LIME DOWN SOLAR PROJECT

**DEADLINE 2 COMMENTS
STOP LIME DOWN**

22 May 2026

APFP Regulation: 5(2)(a)
Application Doc No.: EXAM/9.10
Drawing no.: P4443-LPR-ZZ-XX-M2-Z-EXA-0366

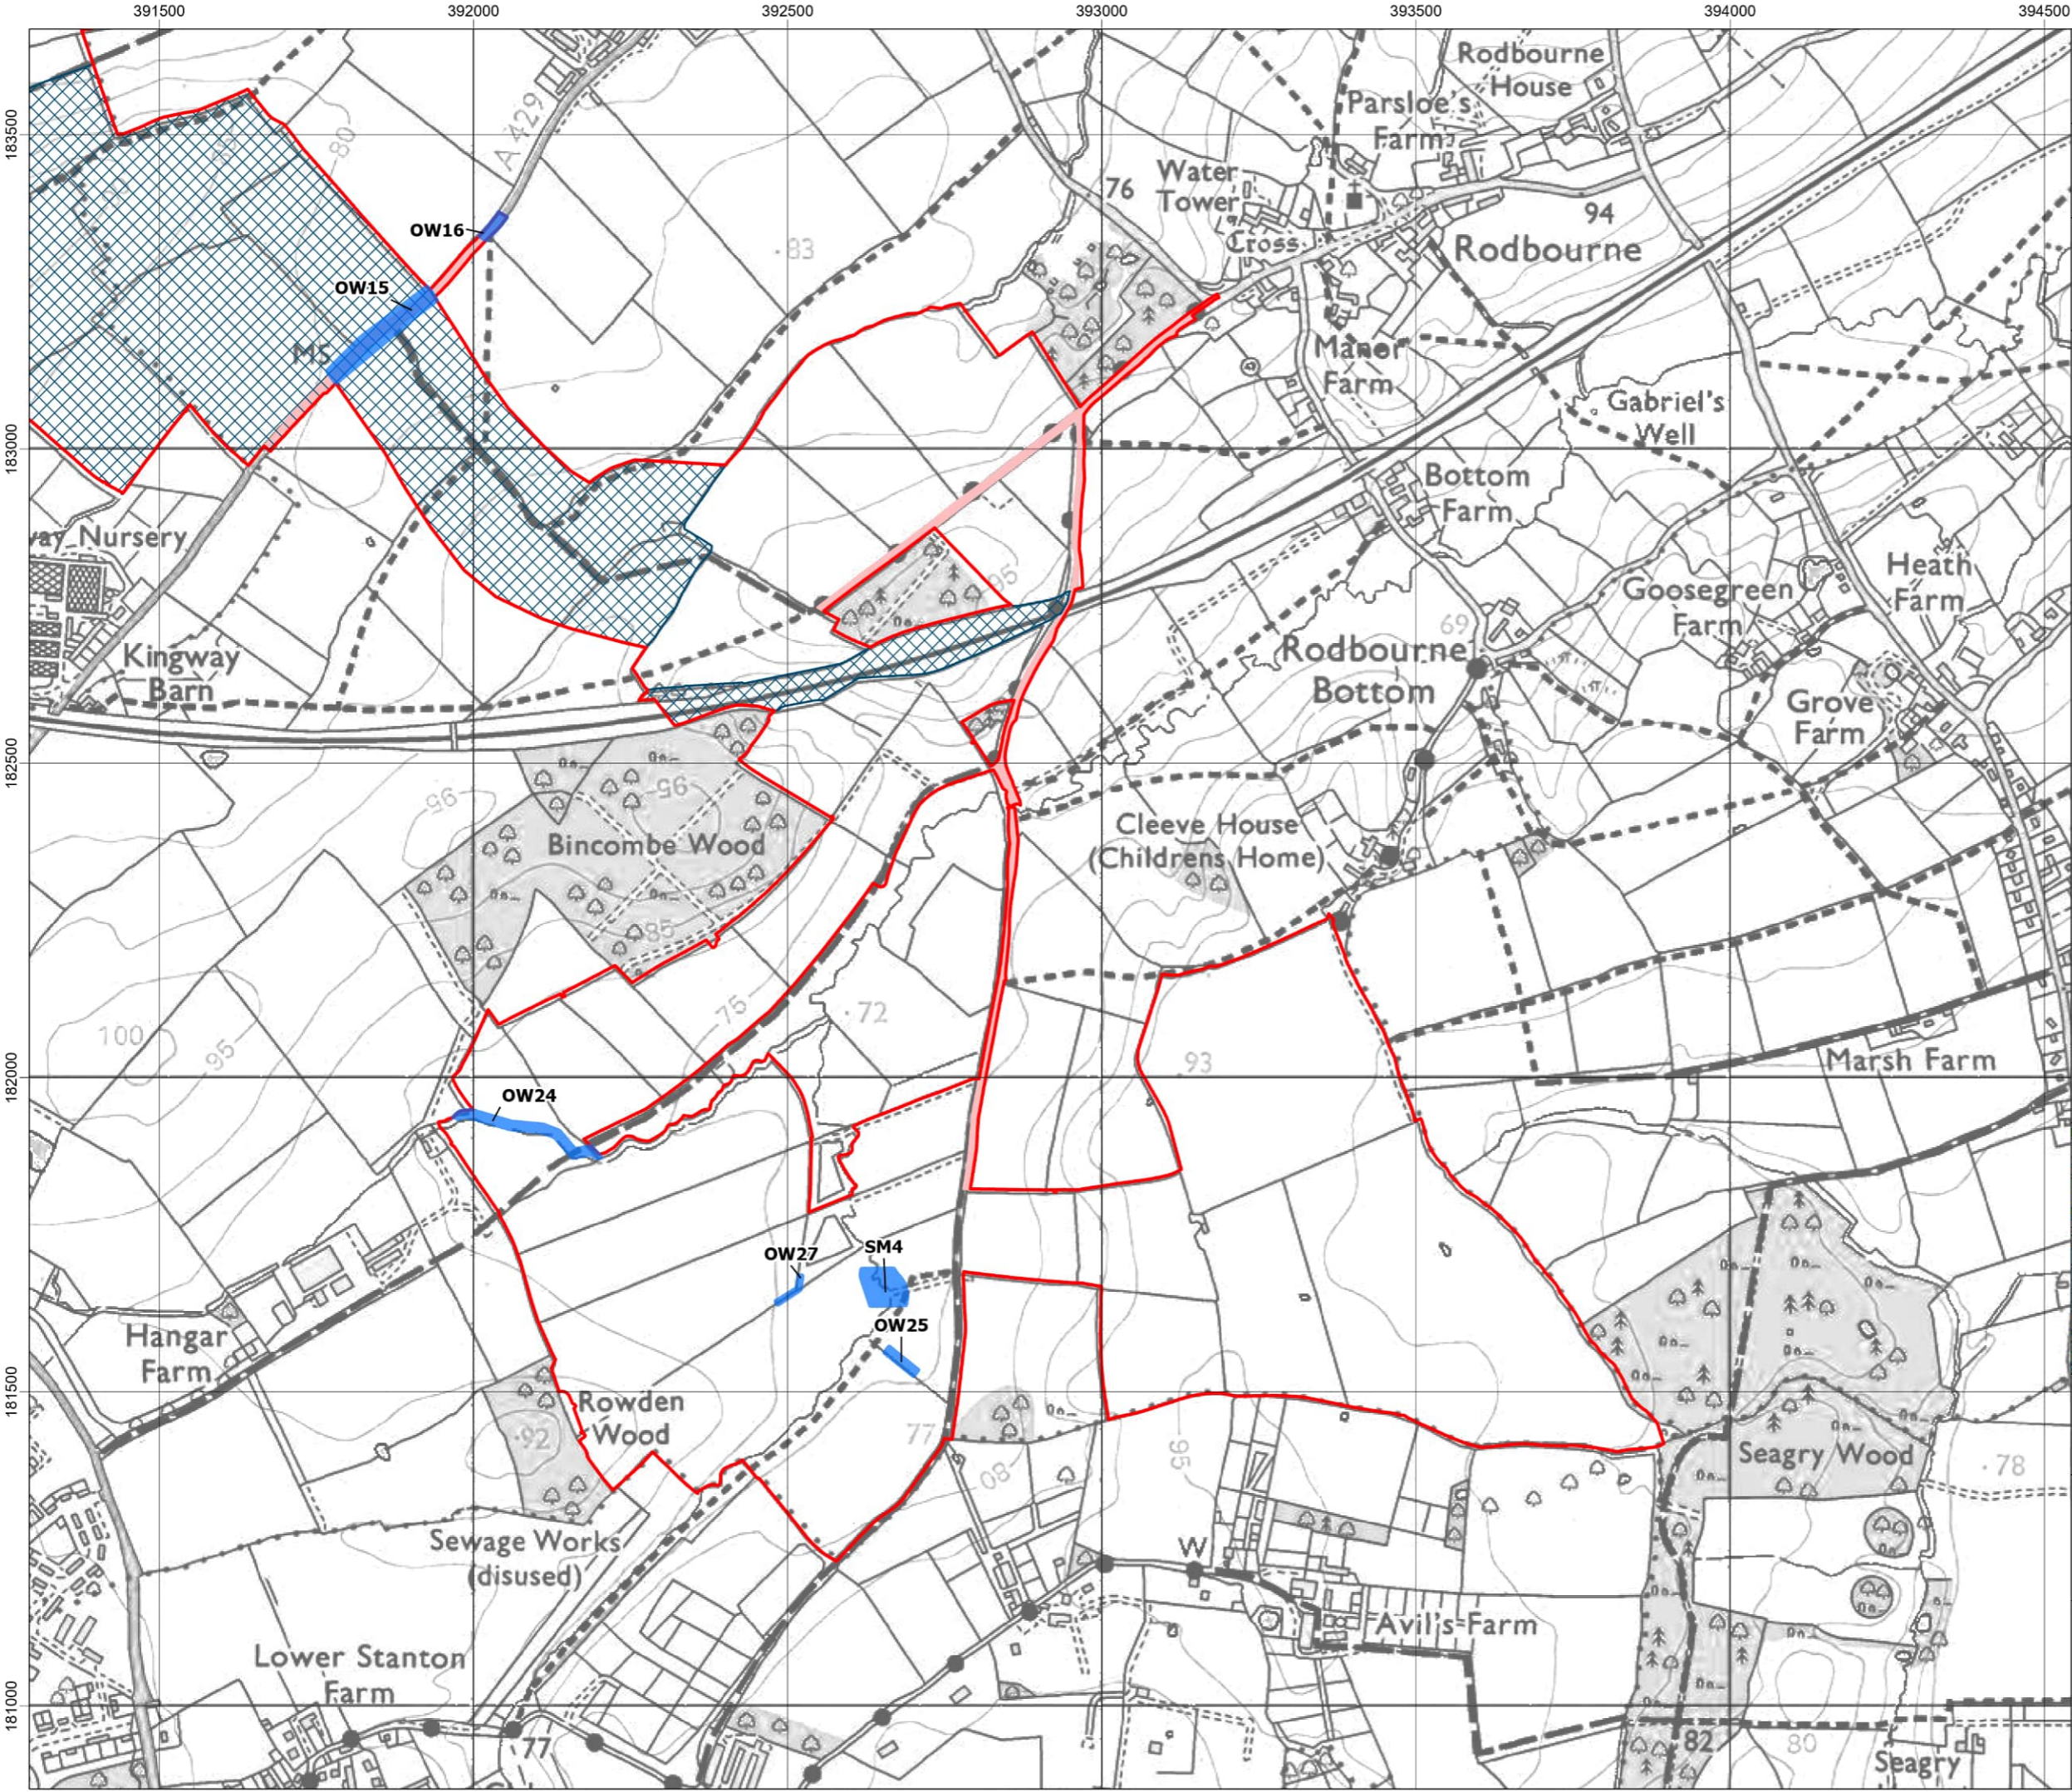
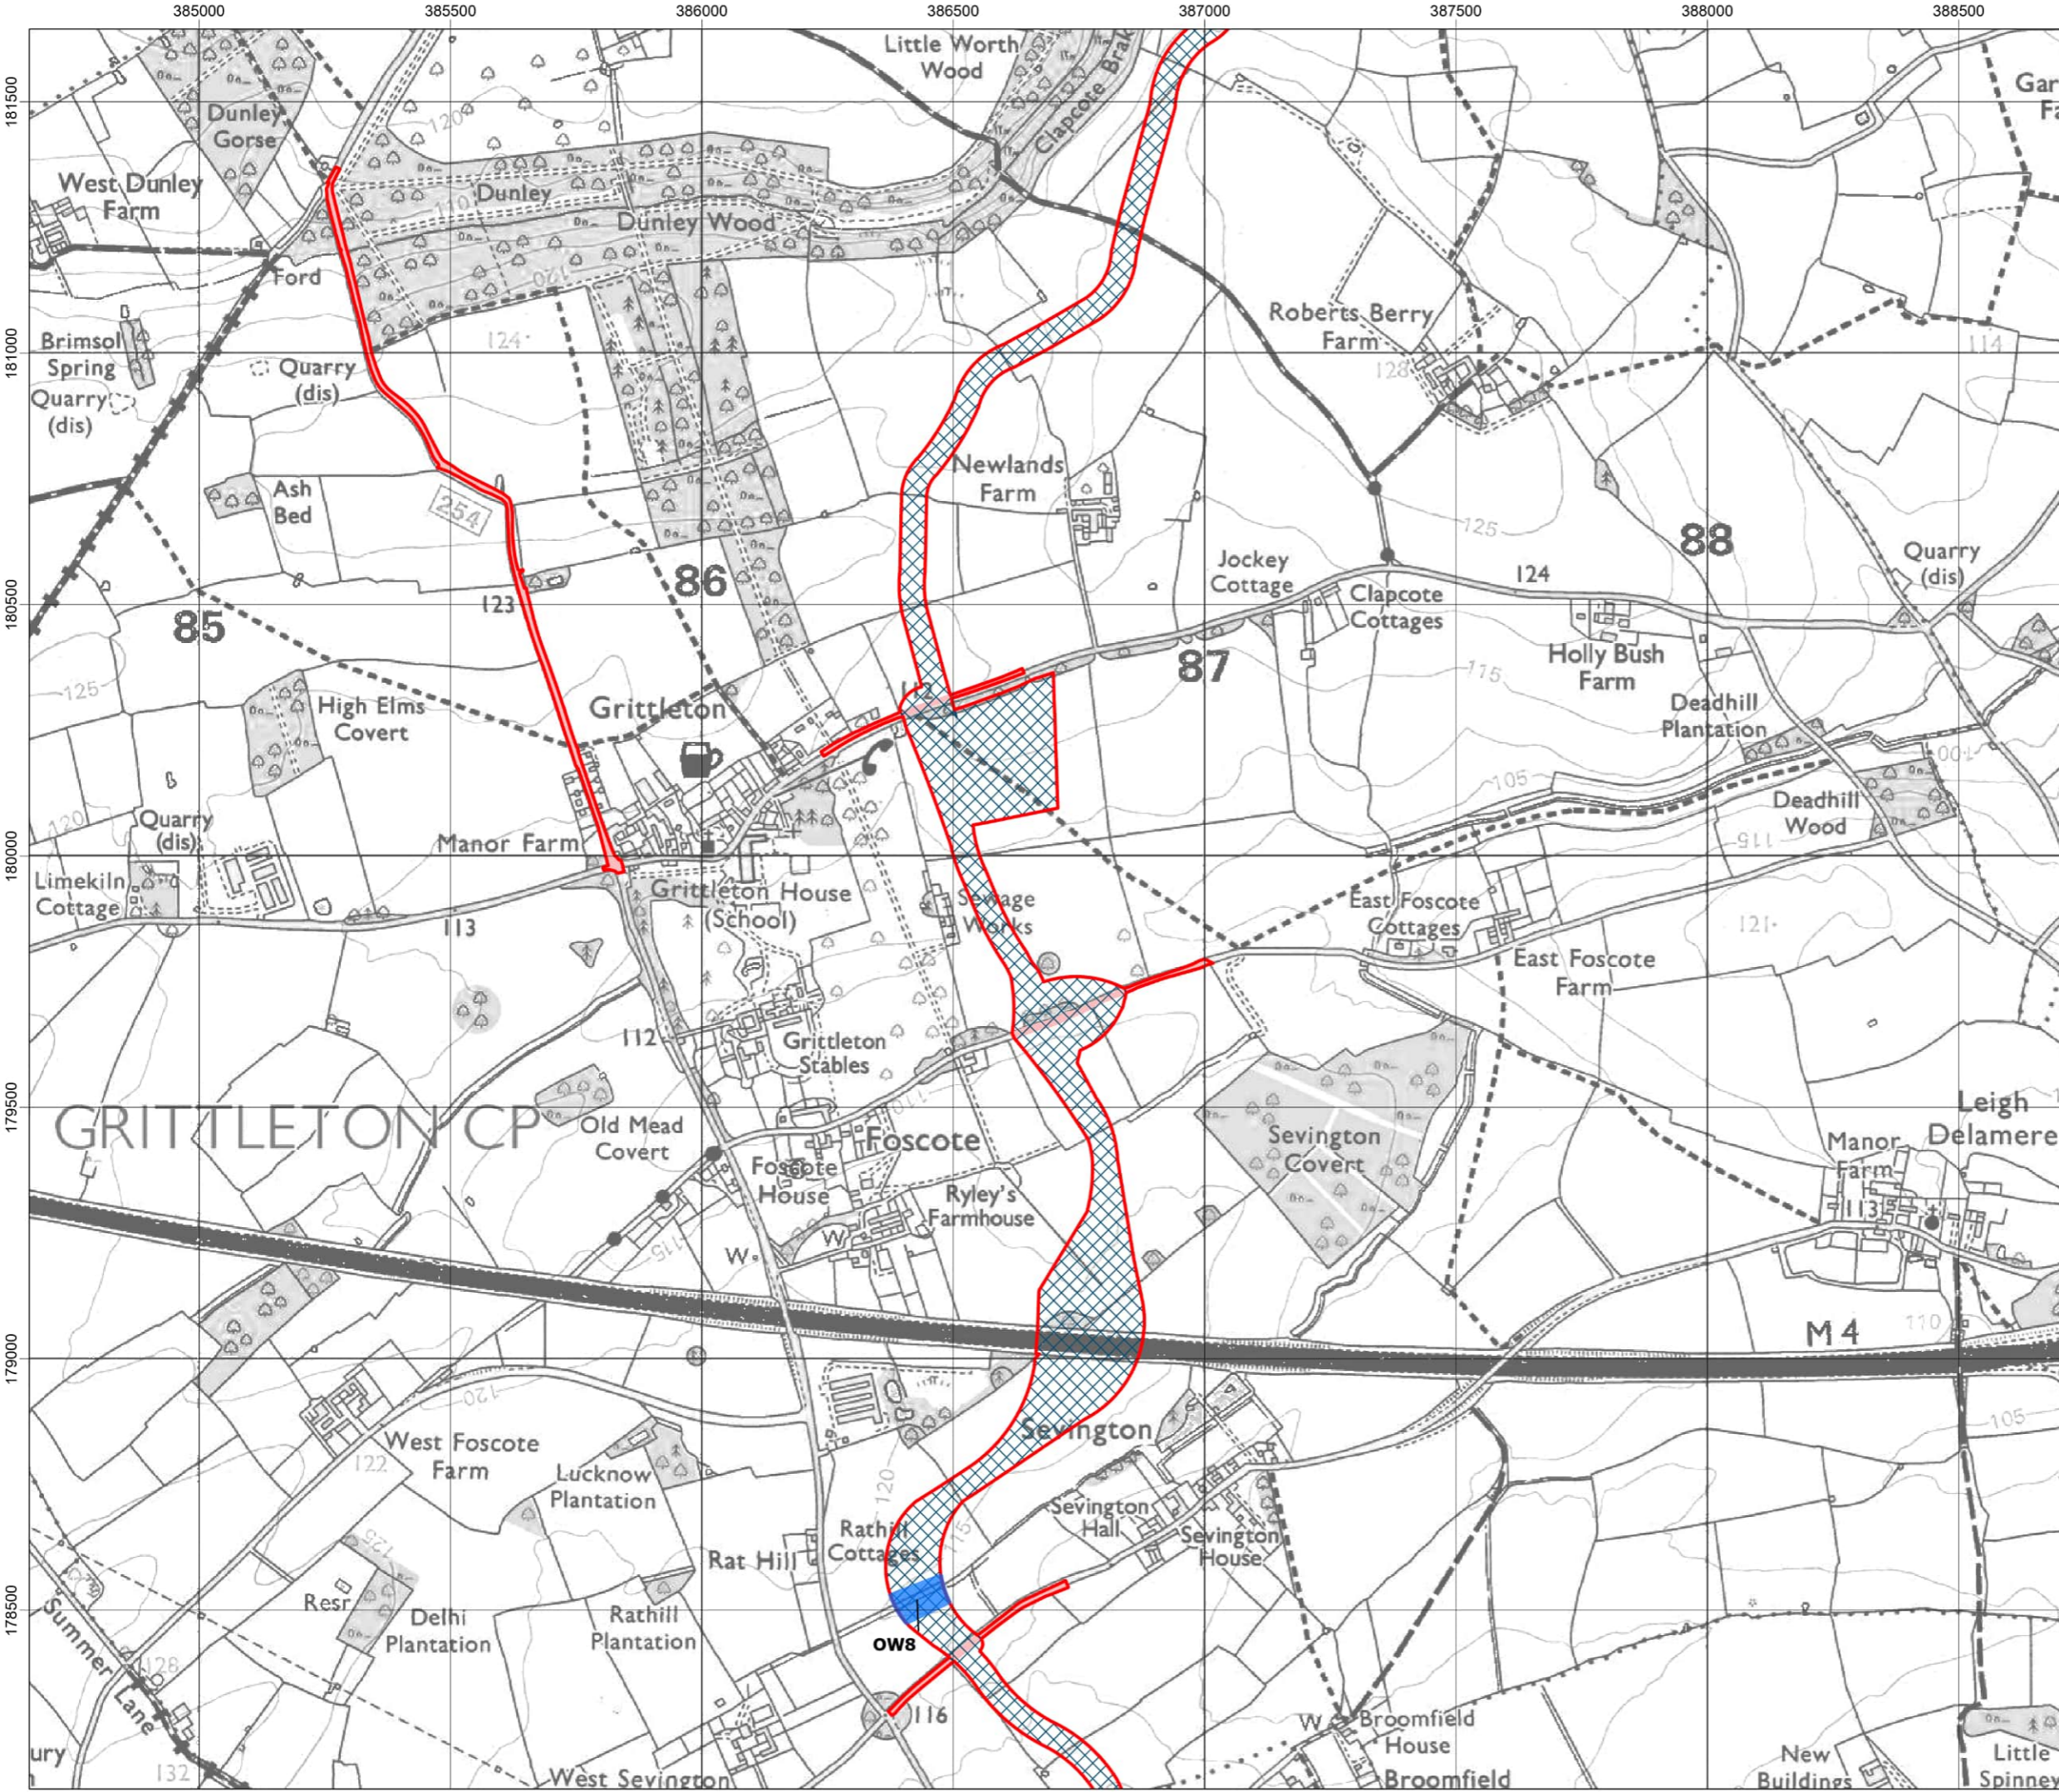
- 2.6.2.1. Minimal changes have been made to the site-specific FRAs and covering report;
- 2.6.2.2. The Firewater Containment Report does not address the credible worst-case scenario of a BESS fire taking more than 4 hours to extinguish;
- 2.6.2.3. It is unclear whether the Watercourse Crossing Schedule is exhaustive and the Schedule would benefit from an accompanying map; and
- 2.6.2.4. The Water Framework Directive Assessment is lacking in necessary detail.
